REPORT UPDATE

Application No: A/8/18/PL

LOCATION: Land Rear of 1 To 6
The Cottrells
Angmering
BN16 4AF

PROPOSAL: Variation of condition 2 imposed under A/173/16/PL to read 'the development to be carried out in accordance with the following approved plans ADC 962/04 REVA, ADC962/13 & ADC962/14 relating to slight repositioning & change in size of building, revised position of rooflights on east, north & south elevations. This application affects the character & appearance of the Angmering Conservation Area.

A		Layout amended		10.11.17	
Rev		Description		Date	
Job Reference		Client			
New House The Cottrells Angmering, BN16 4AF		AM Homes Ltd			
Drawing Title		Drawing No		Rev	
Ground Floor Plan		ADC962/04		A	
Date	Scale	Dwg Size	Plot Style	Drawn	Checked
24.04.17	1:100	A3	ADC-red	TGS	AD

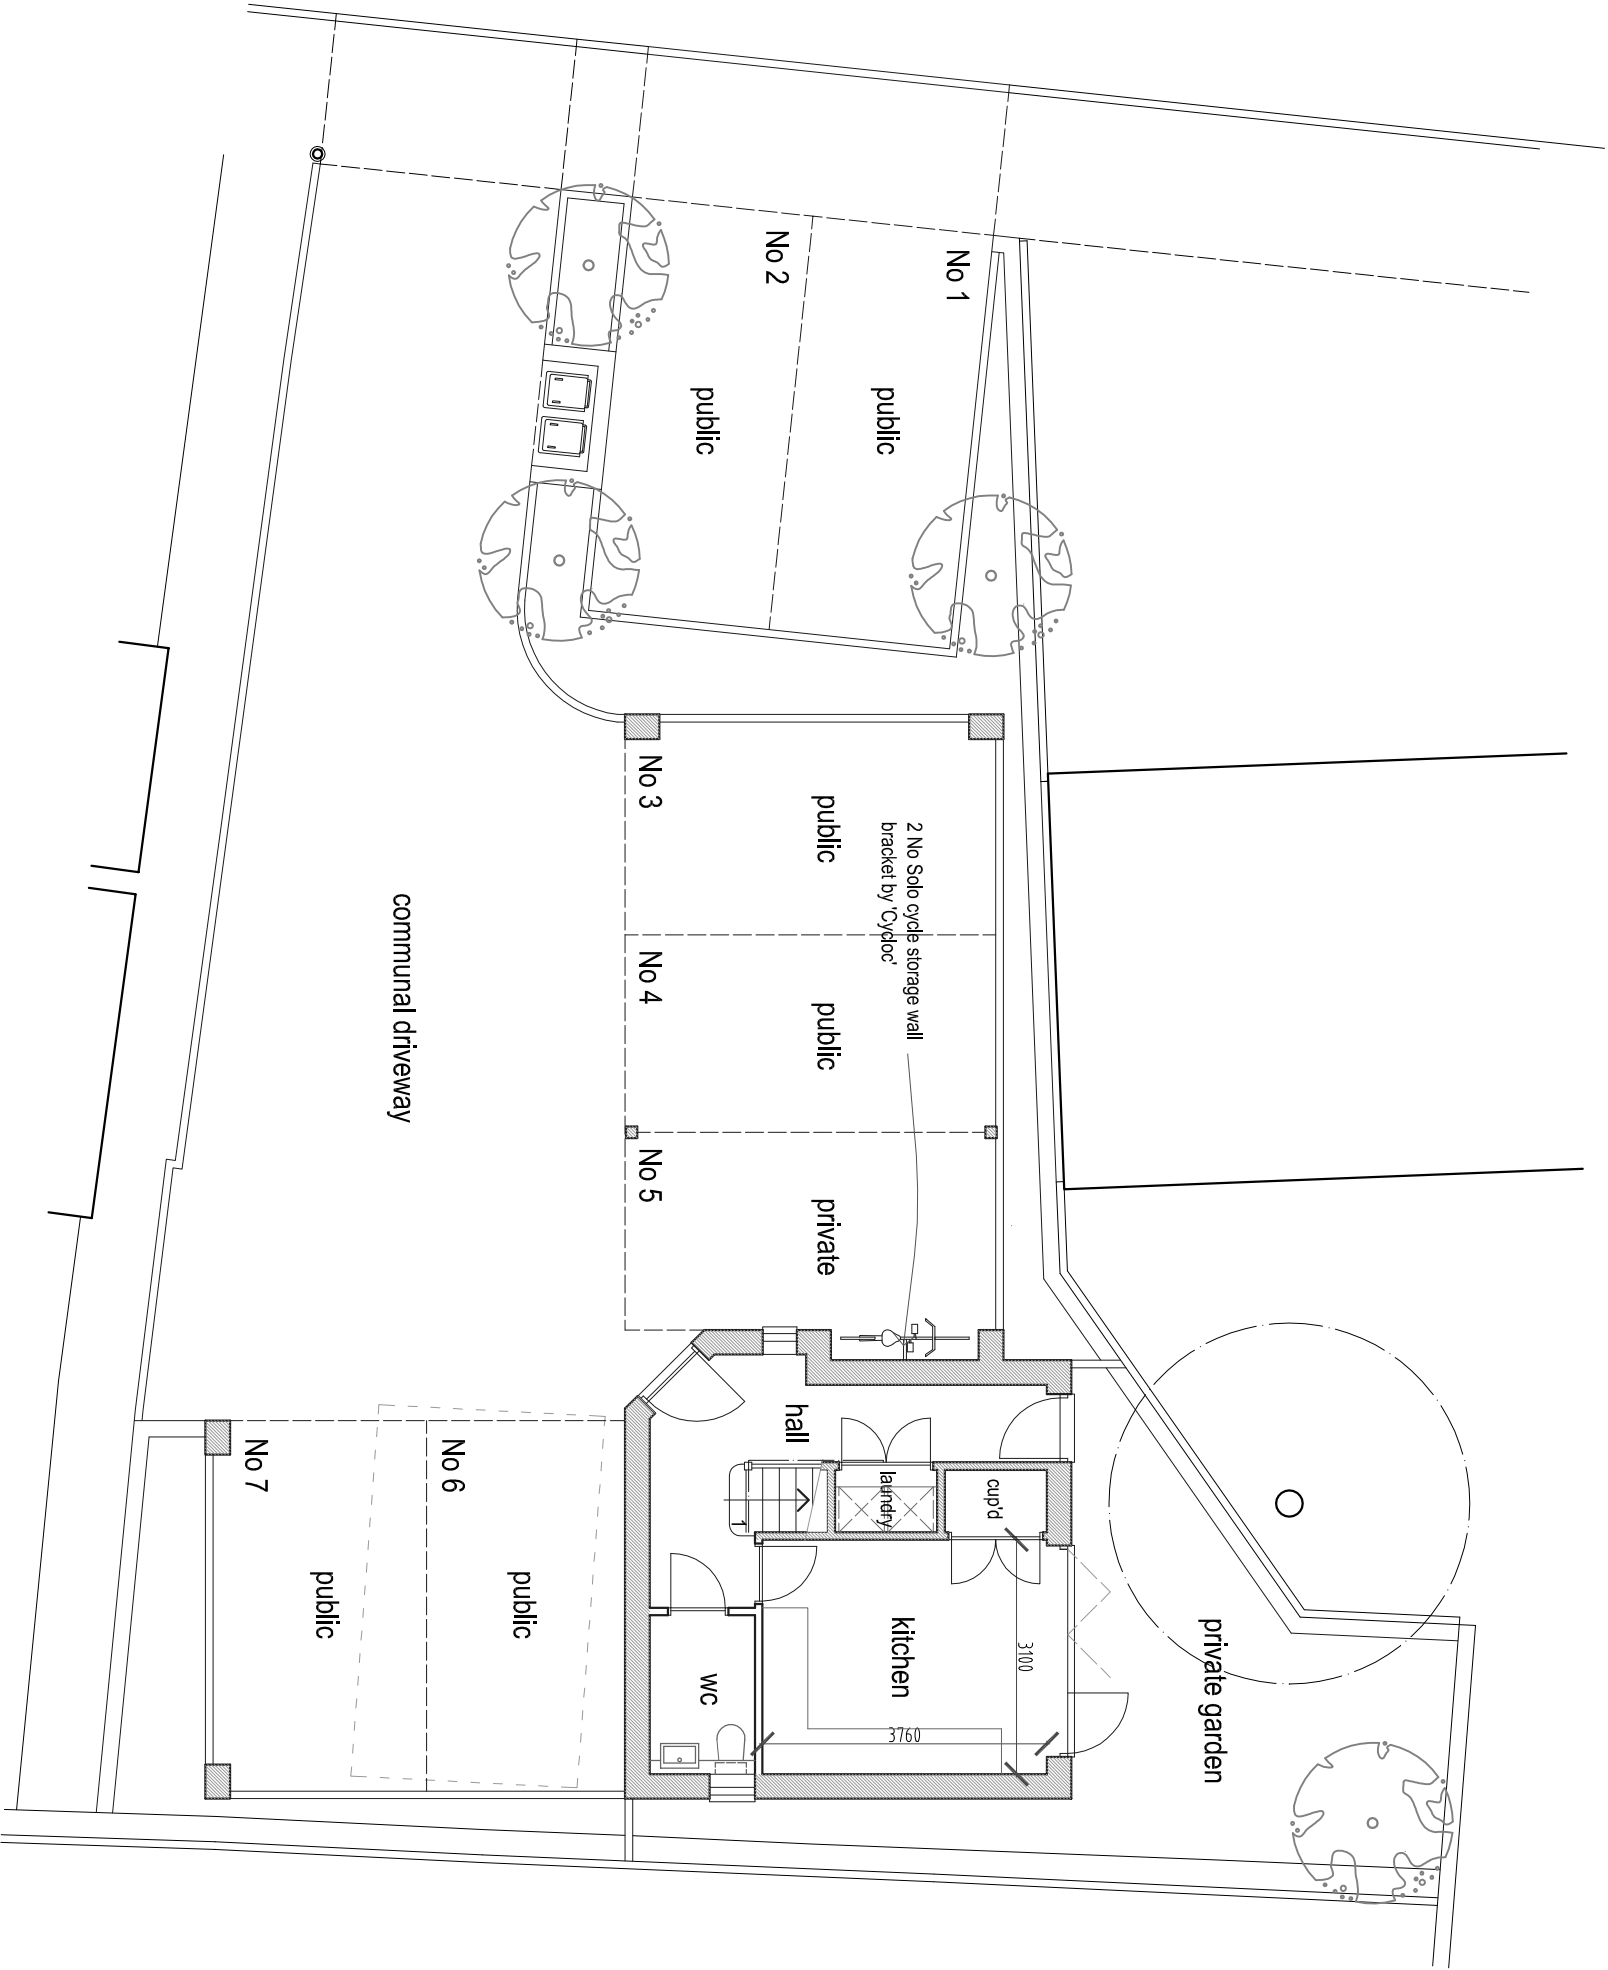
- The as built layout matches that in drawing ADC962/04 submitted for application A/162/17/PL with Bedroom 1 with an en-suite shower room downstairs. This application was refused in 2017. As no kitchen has been installed downstairs, one can assume that the intention must be to install it upstairs. The refused application defined a three bedroom scheme with a galley kitchen in the upstairs living area.

- Condition 2 of Conditionally Approved A/173/16/PL identifies that no external or internal changes are permitted without approval. The downstairs layout appears to have been built as a bedroom with en-suite

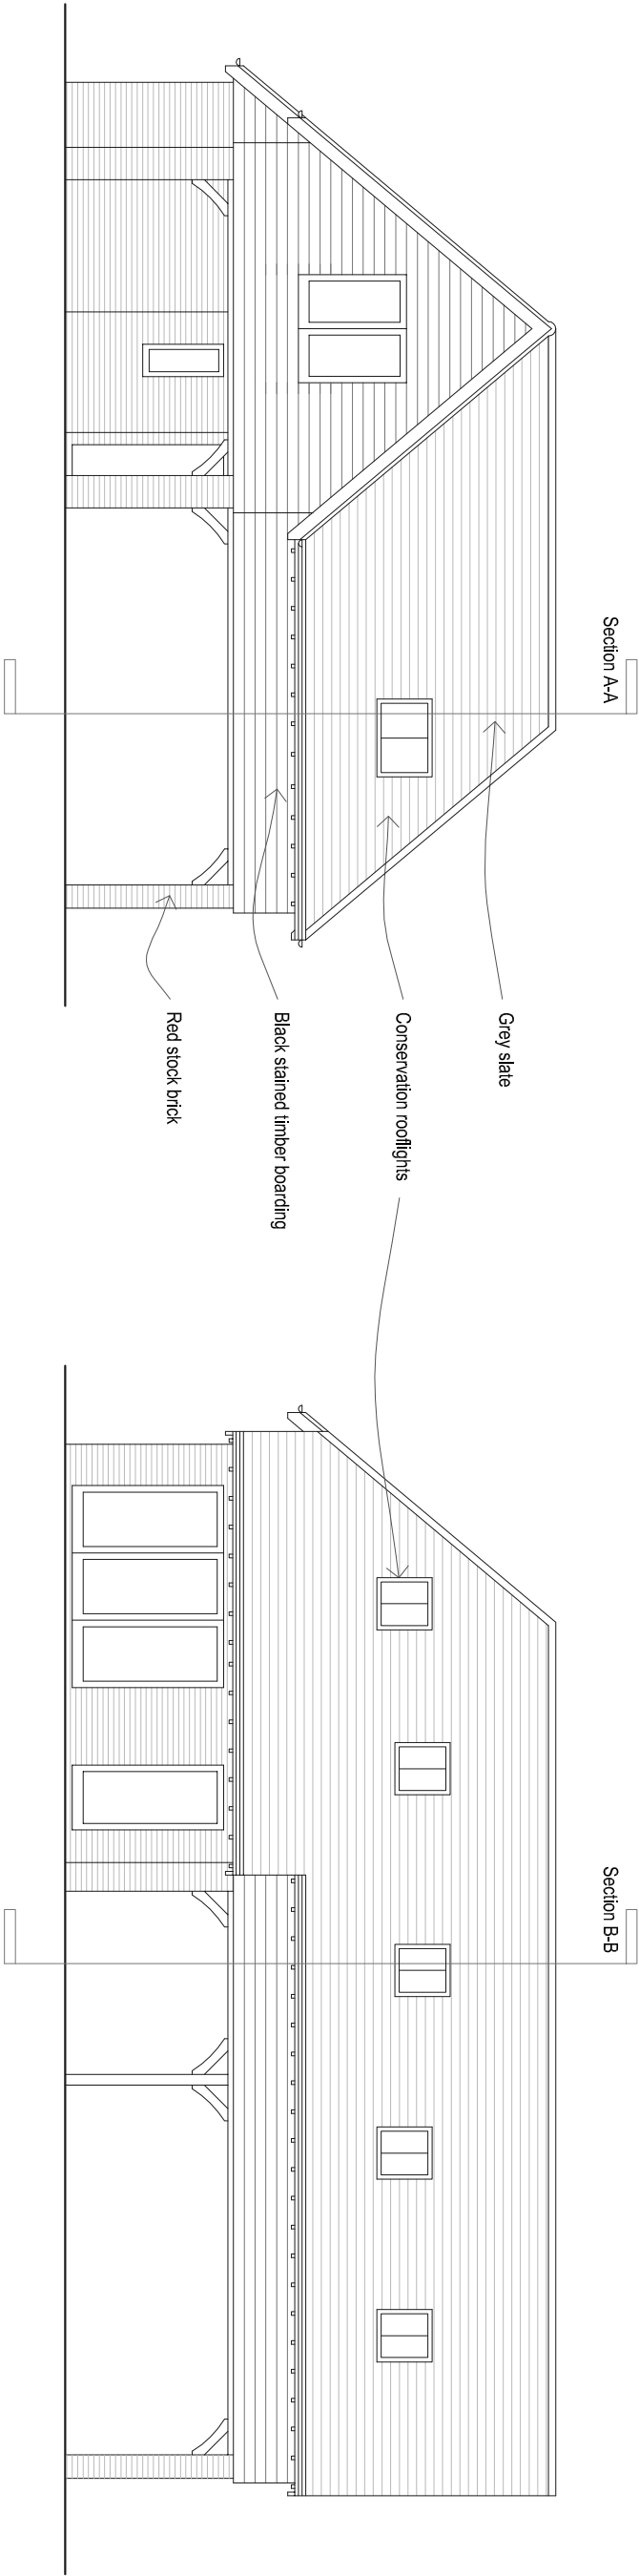
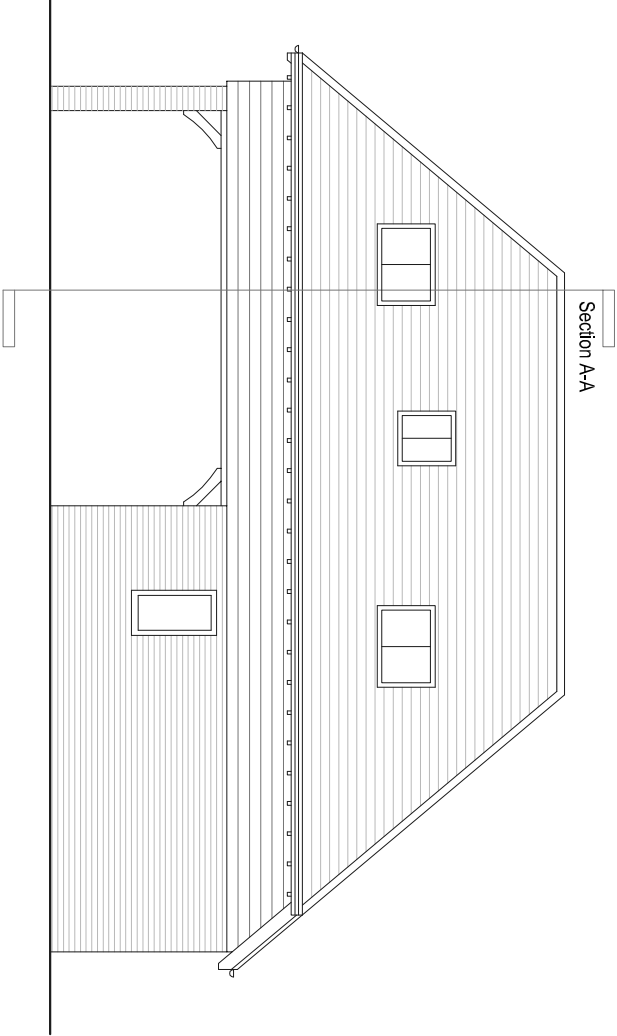
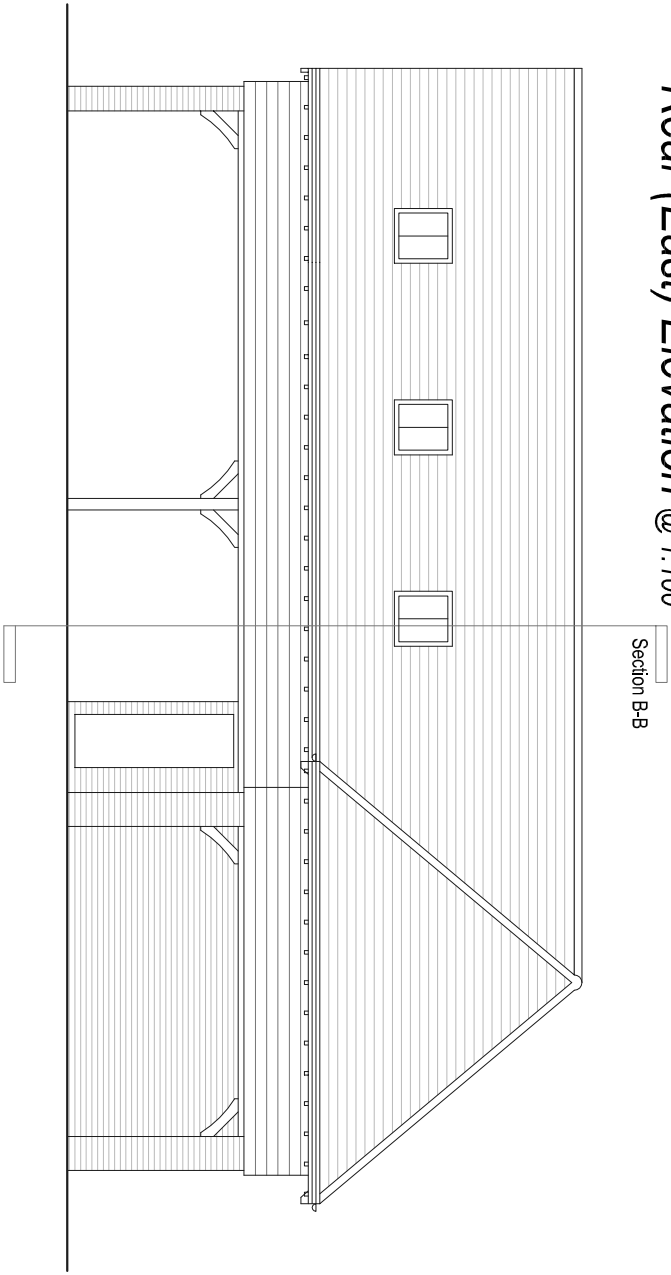
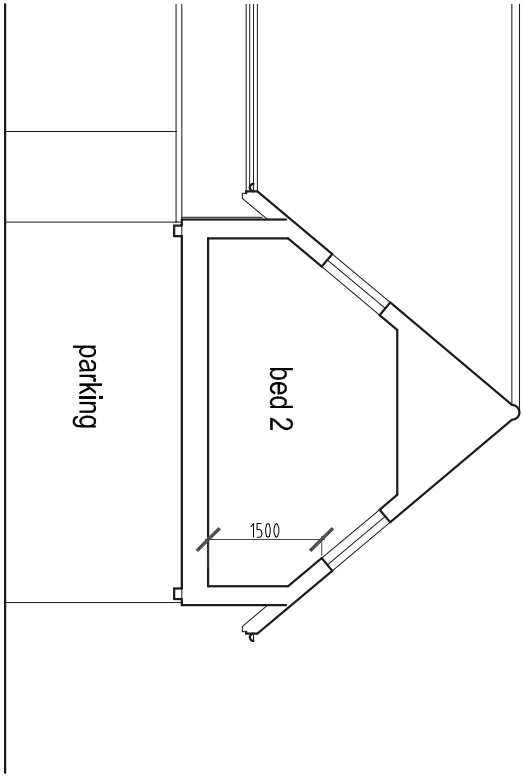
- The current application shows the fully opening windows that have been installed instead of the escape roof lights approved by the committee. These installed windows appear to be 30% larger than those shown in the approved plans. The positioning and cill height of the windows mean they give a direct view into neighbouring properties. Surely this was never the committee's intention when approving the plans. My understanding was that the approved roof lights would not have opened except in an emergency.

- Would like assurance that ground level will be the same as the surrounding area.
- Roof profile should be hipped as approved originally.
- Roof light windows should be escape windows and in the correct position (1.5m from the internal floor to the lower sill). The lower height results in overlooking into rear bedroom windows of 1-6 The Cottrells and the property to the rear.

- Drop kerb - at present there has been a dropped kerb built to allow access to two of the public parking spaces being built as part of the project.
- The number of windows on the north elevation has reduced from six to five. Two have cill heights at 1.7m. Only one of the three roof lights in the east elevation has changed. It is now a little higher.

This proposal relates to the revised position of roof lights and therefore loss of privacy is the main consideration in respect of impact on residential amenity. The cross section A-A indicates that the height of the windows on the east and west roof slopes have not decreased and are as previously. The more centrally located bathroom window is higher than originally approved reducing the opportunity for over looking if the window is open.

One of the lounge windows on the south elevation has been reduced in height to be level with 2 lower window positions previously approved. These windows have a cill height of 1.5 which is the same as the lower cill height previously approved. This has a lowest outside height of 1.7m which is considered adequate to prevent any materially adverse overlooking effects and loss of privacy to adjoining gardens.

Two of the windows on the north elevation have increased in height to have an internal cill height of 1.7m and the others remain in the position approved with an internal cill height of 1.5m. These heights are considered adequate to prevent materially adverse overlooking resulting to adjoining properties or their gardens.

Rev		Description	Date	
Job Reference New House The Cottrells Angmering, BN16 4AF			Client AM Homes Ltd	
Drawing Title Planning Permission Comparison Plan			Drawing No ADC962/18	Rev
Date 10.05.18	Scale 1:100	Dwg Size A3	Plot Style ADC-red	Drawn AD
			Checked AD

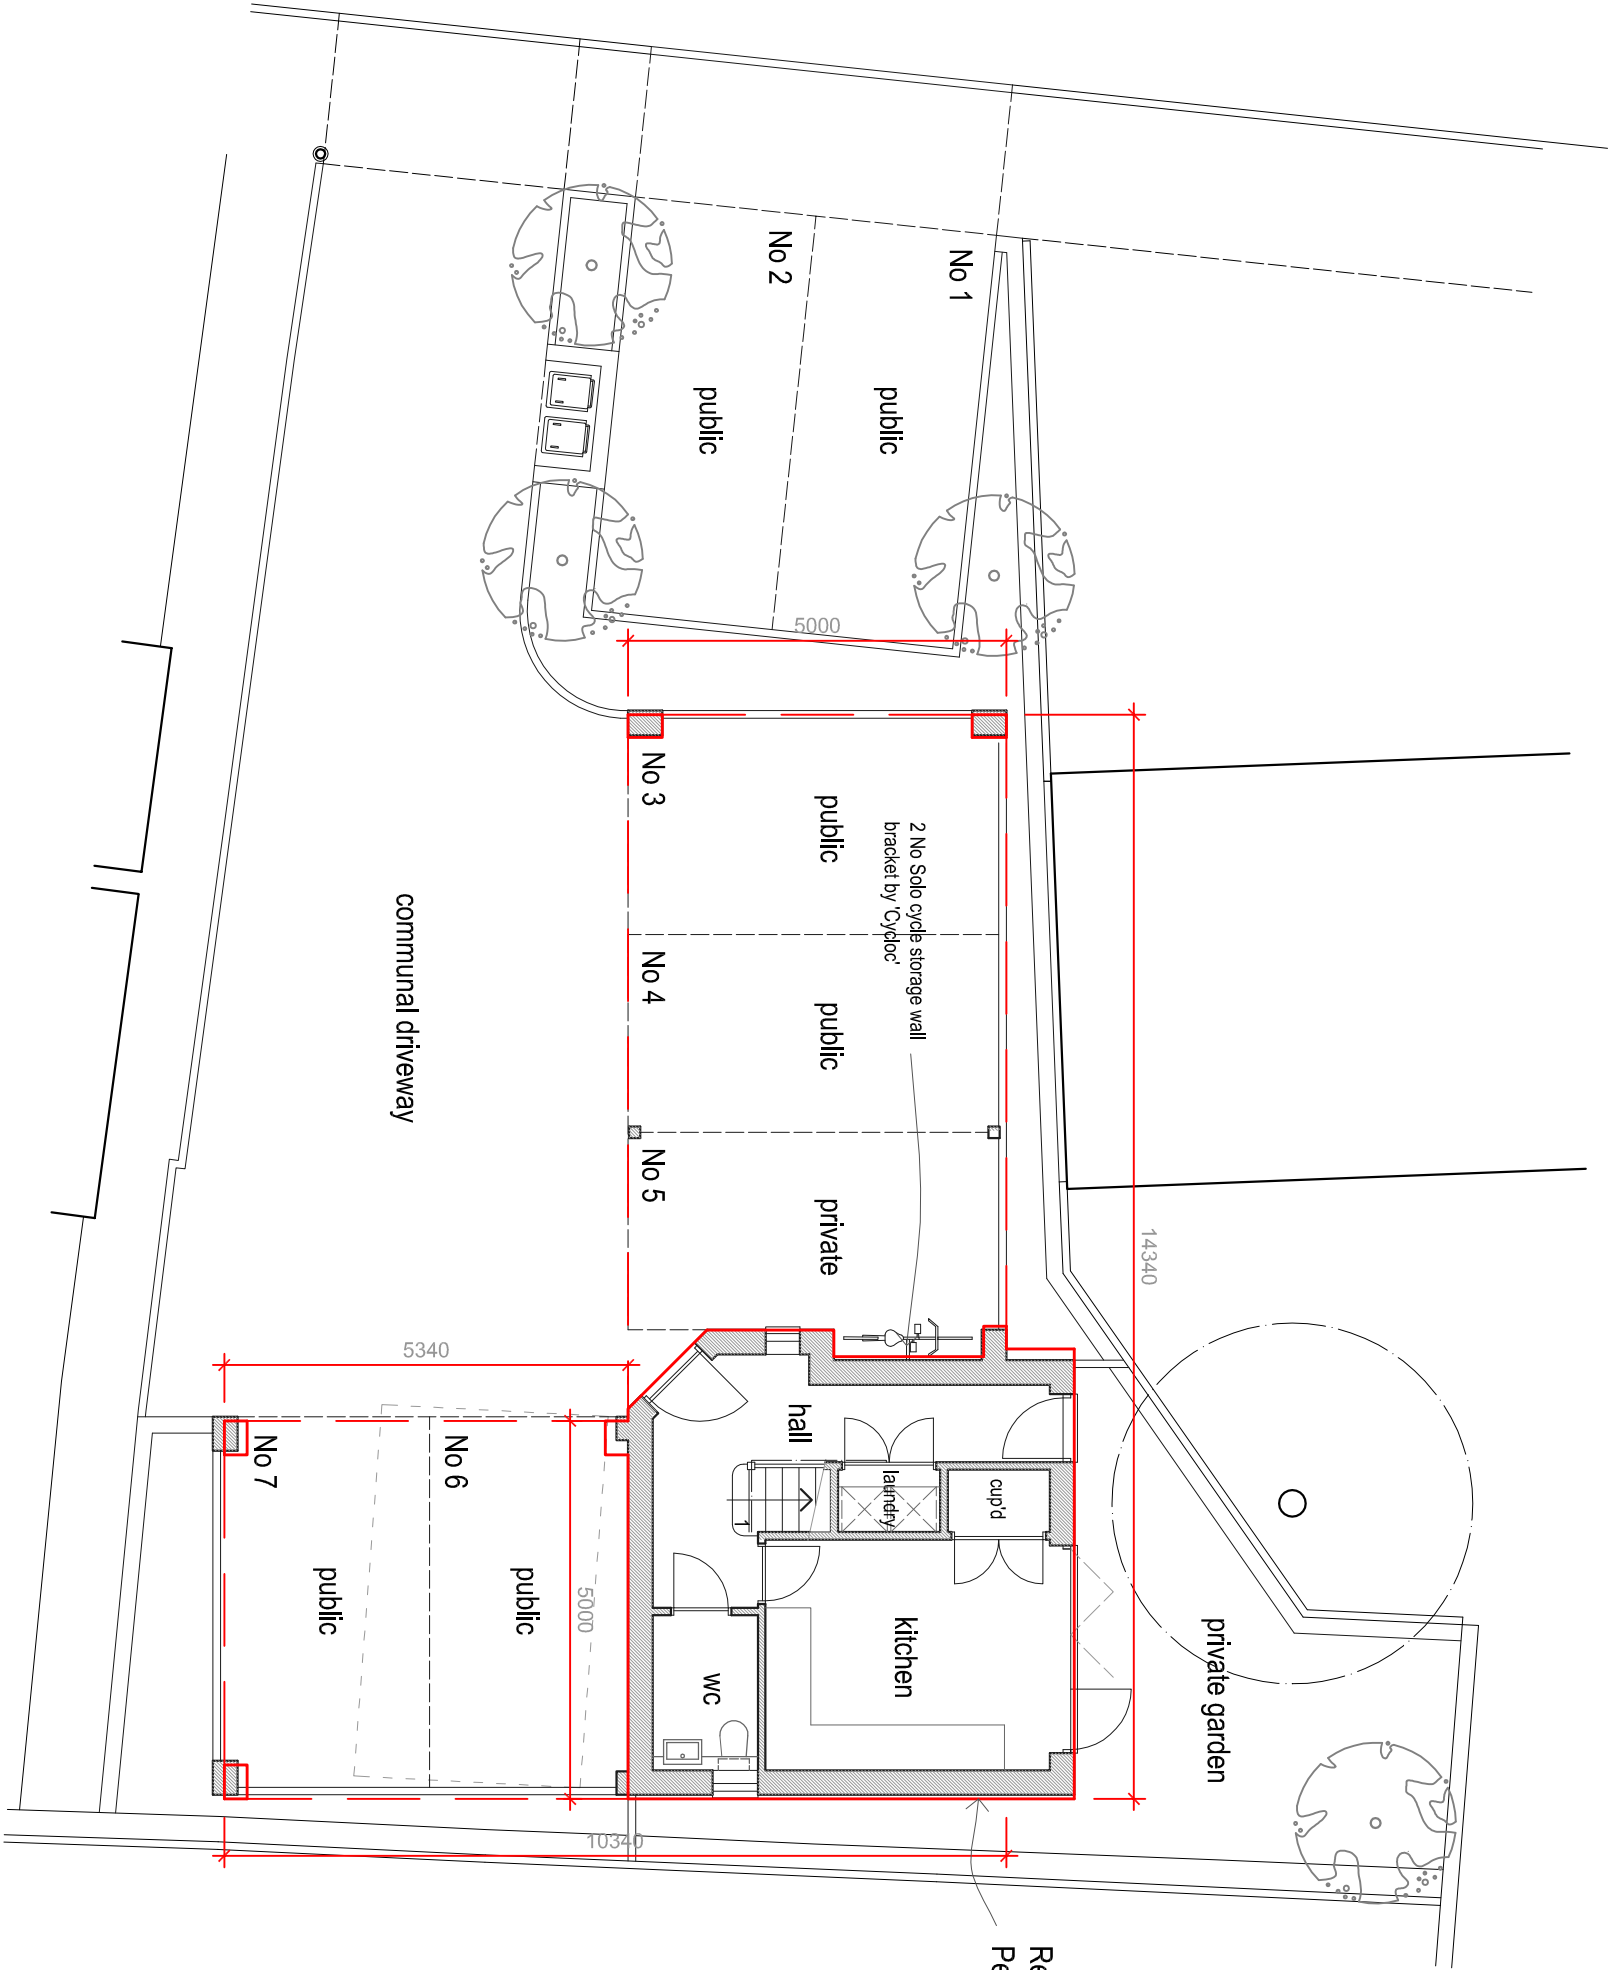
The agent has checked the site dimensions and confirmed drawings No ADC 962/04A, 13A & 14A are correct as built and do not need amending to reflect what has been built. Drawing ADC 962/18 shows the approved building outline in red. The footprint is generally in line with the approved scheme but there are small discrepancies because the foundations had to be piled and piling is not always an exact science.

- additional drawing ADC962/18 showing the amended footprint does not match what has been built with regards to the internal layout of the ground floor. There is a new door within the room identified as the KITCHEN that opens into what is identified as the WC. A shower cubical (with chrome edging and handle) can be clearly seen in this room. Also there do not appear to be any mains sockets in the walls at worktop height which is a common feature in all kitchens. Neither the door or shower are shown on drawing ADC962/18.
